**Consultation Response from KC,  
Lead Local Flood Authority**

**2024/92576 site of, Former Spotted Cow Pub, New Hey Road, Oakes, Huddersfield, HD3 4BU**

**Discharge of details reserved by conditions 3 (CMP), 21 (retaining walls), 23 (surface water) and 28 (non-native species) of previous permission 2021/94029 for demolition of existing structures and erection of foodstore (class E) with associated access, parking, servicing areas and landscaping**

**Date Responded: 7<sup>th</sup> February 2025**

TYPICAL CATCHPIT
CHAMBER DETAIL

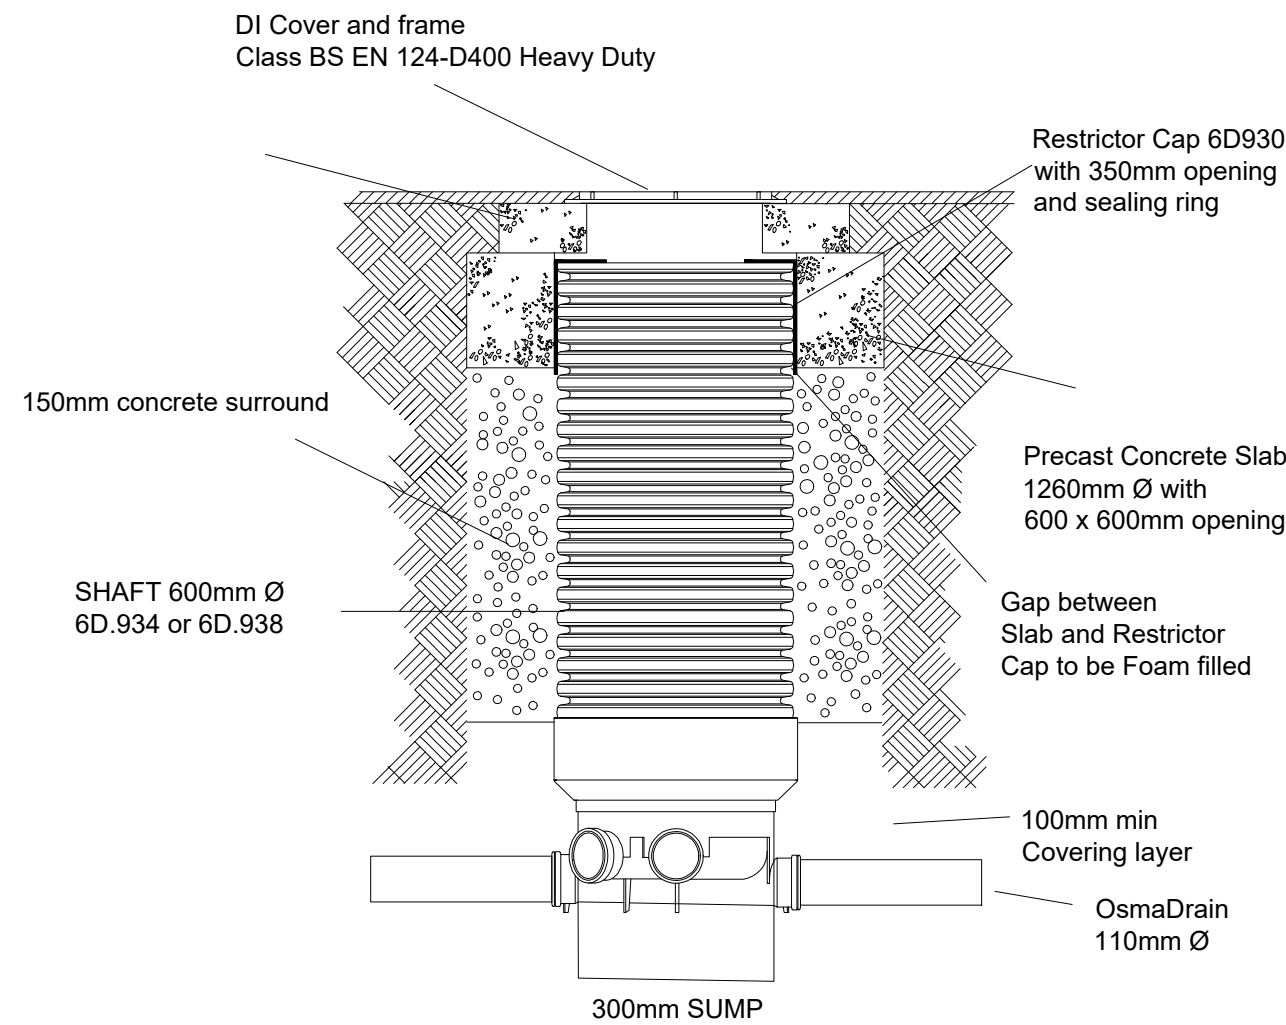
Many of the maintenance concepts are not relevant to the design selected (suggests green suds) which suggests this wasn't a bespoke maintenance plan. However, the relevant areas are acknowledged and is accepted without prejudice to future applications. Catchpit manholes are shown on the drawings

TYPICAL POLYSTORM ATTENUATION DETAIL

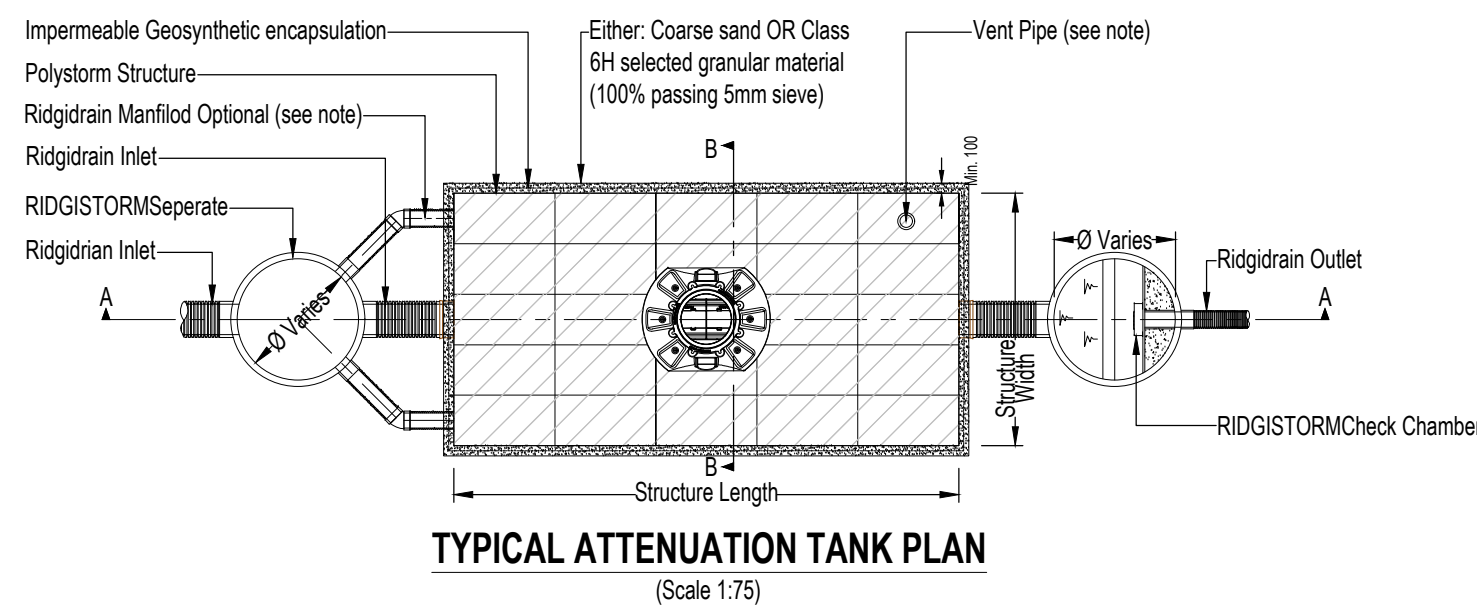
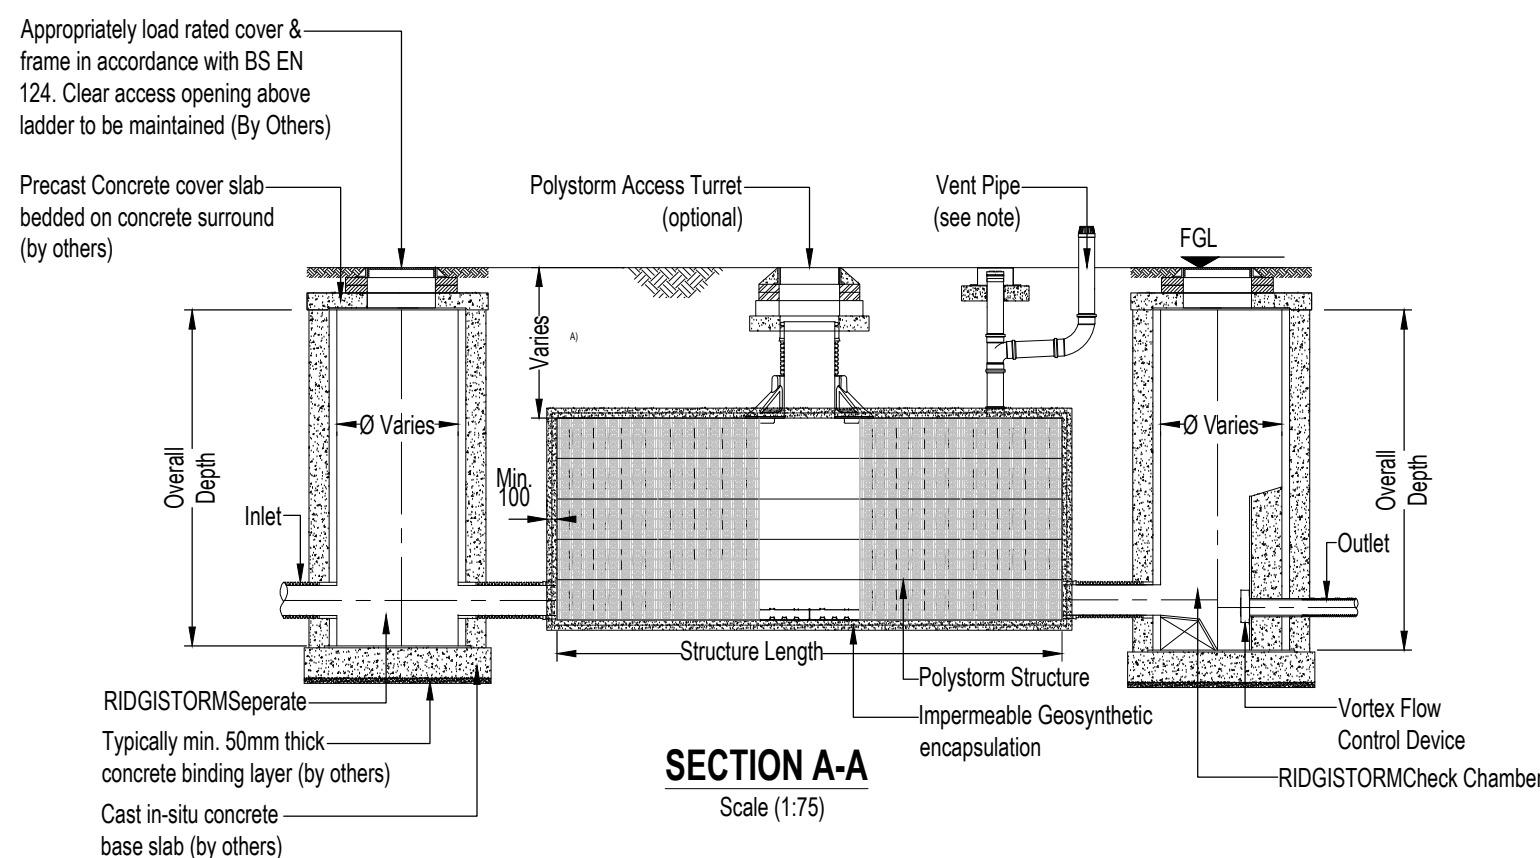
An assessment of the max weight of vehicles to be visiting the site (HGV's, e.g. delivery trucks) in relation to minimum depths required from Polystorm R has been supplied. A protective slab is also now included. Access into the crate storage is now shown for both attenuation features.
